**EL PASO COUNTY PLANNING AND
 COMMUNITY DEVELOPMENT
 DEPARTMENT**

GRADING AND EROSION CONTROL PLAN CHECKLIST

SHEET 4 OF 10
 JOB NO. 25149.01

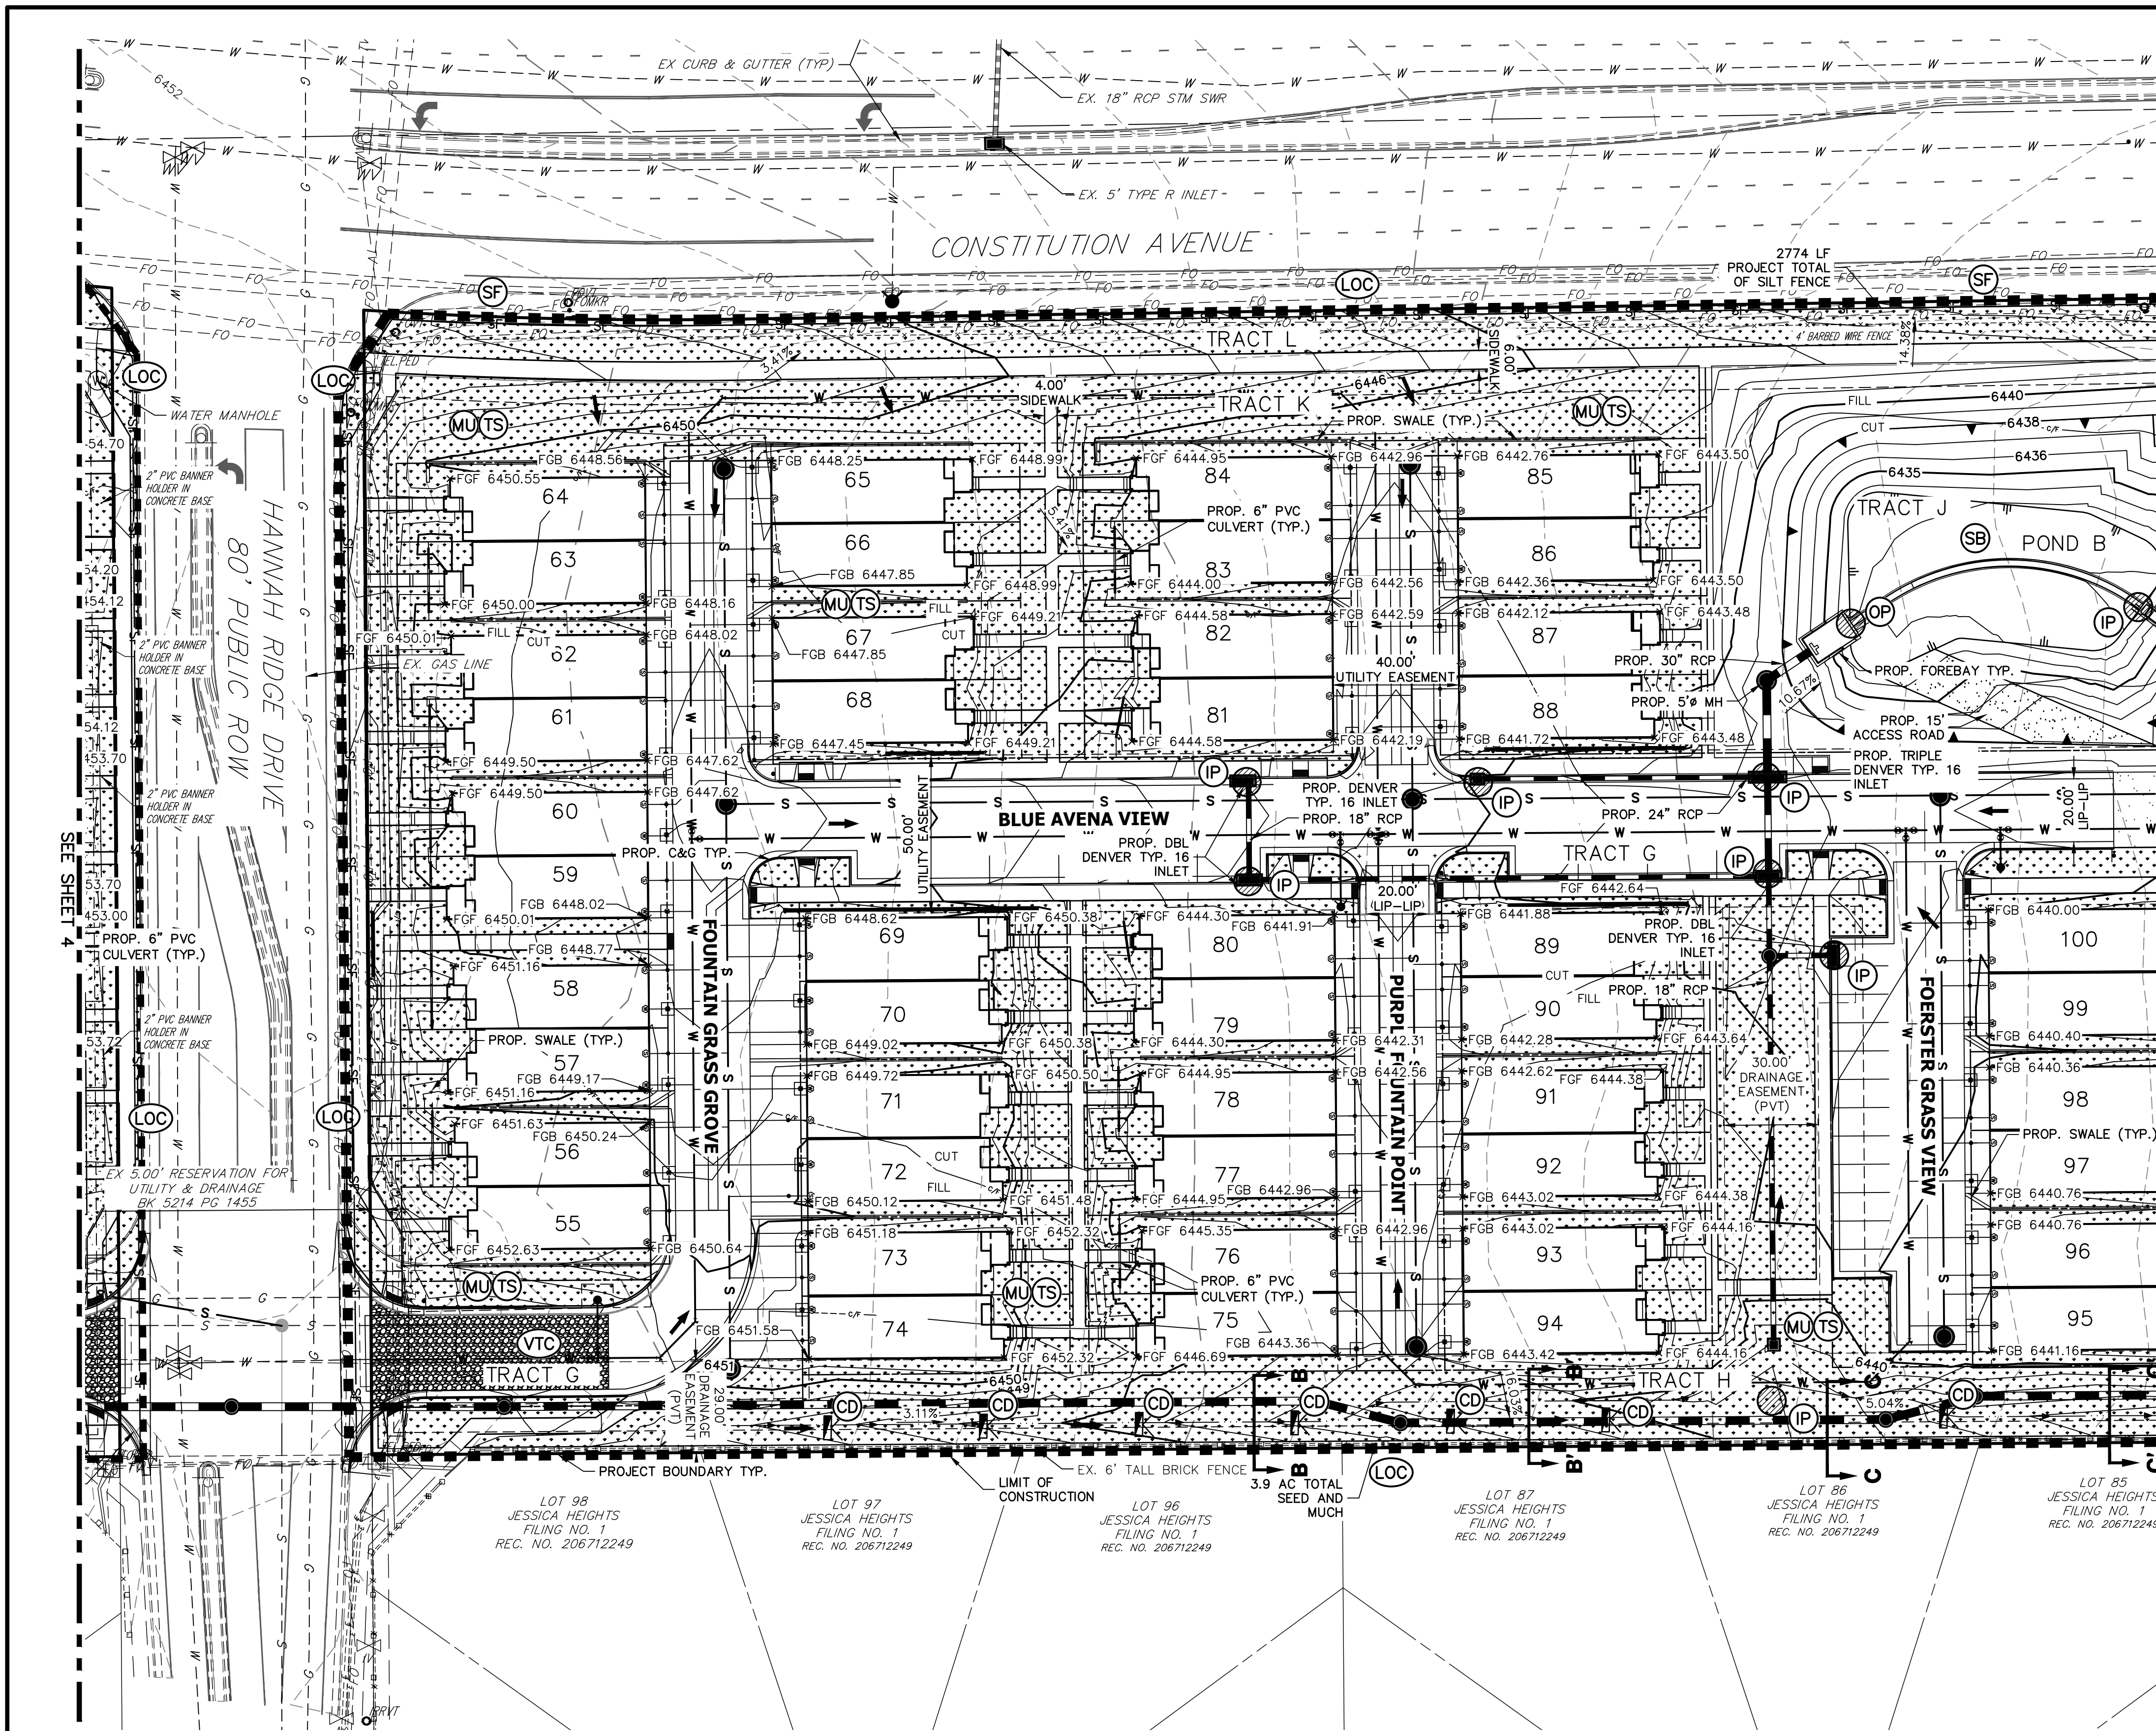
Applicant	PCD
1. GRADING AND EROSION CONTROL PLAN			
a	Vicinity map.	X	✓
b	Adjacent city/town/jurisdictional boundaries, subdivision names, and property parcel numbers labeled.	X	✓
c	North arrow and acceptable scale (1"=20' to 1"=100').	X	✓
d	Legend for all symbols used in the plan. see comment on Sheet 4	X	X
e	Existing and proposed property lines. Proposed subdivision boundary for subdivision projects.	X	✓
f	All existing structures.	X	✓
g	All existing utilities.	X	✓
h	Construction site boundaries.	X	✓
i	Existing vegetation (notes are acceptable in cases where there is no notable vegetation, only grasses/weeds, or site has already been stripped). see comment on Sheet 3	X	X
j	FEMA 100-yr floodplain.		N/A
k	Existing and proposed water courses including springs, streams, wetlands, detention ponds, stormwater quality structures, roadside ditches, irrigation ditches and other water surfaces. Show maintenance of pre-existing vegetation within 50 feet of a receiving water.	X	✓
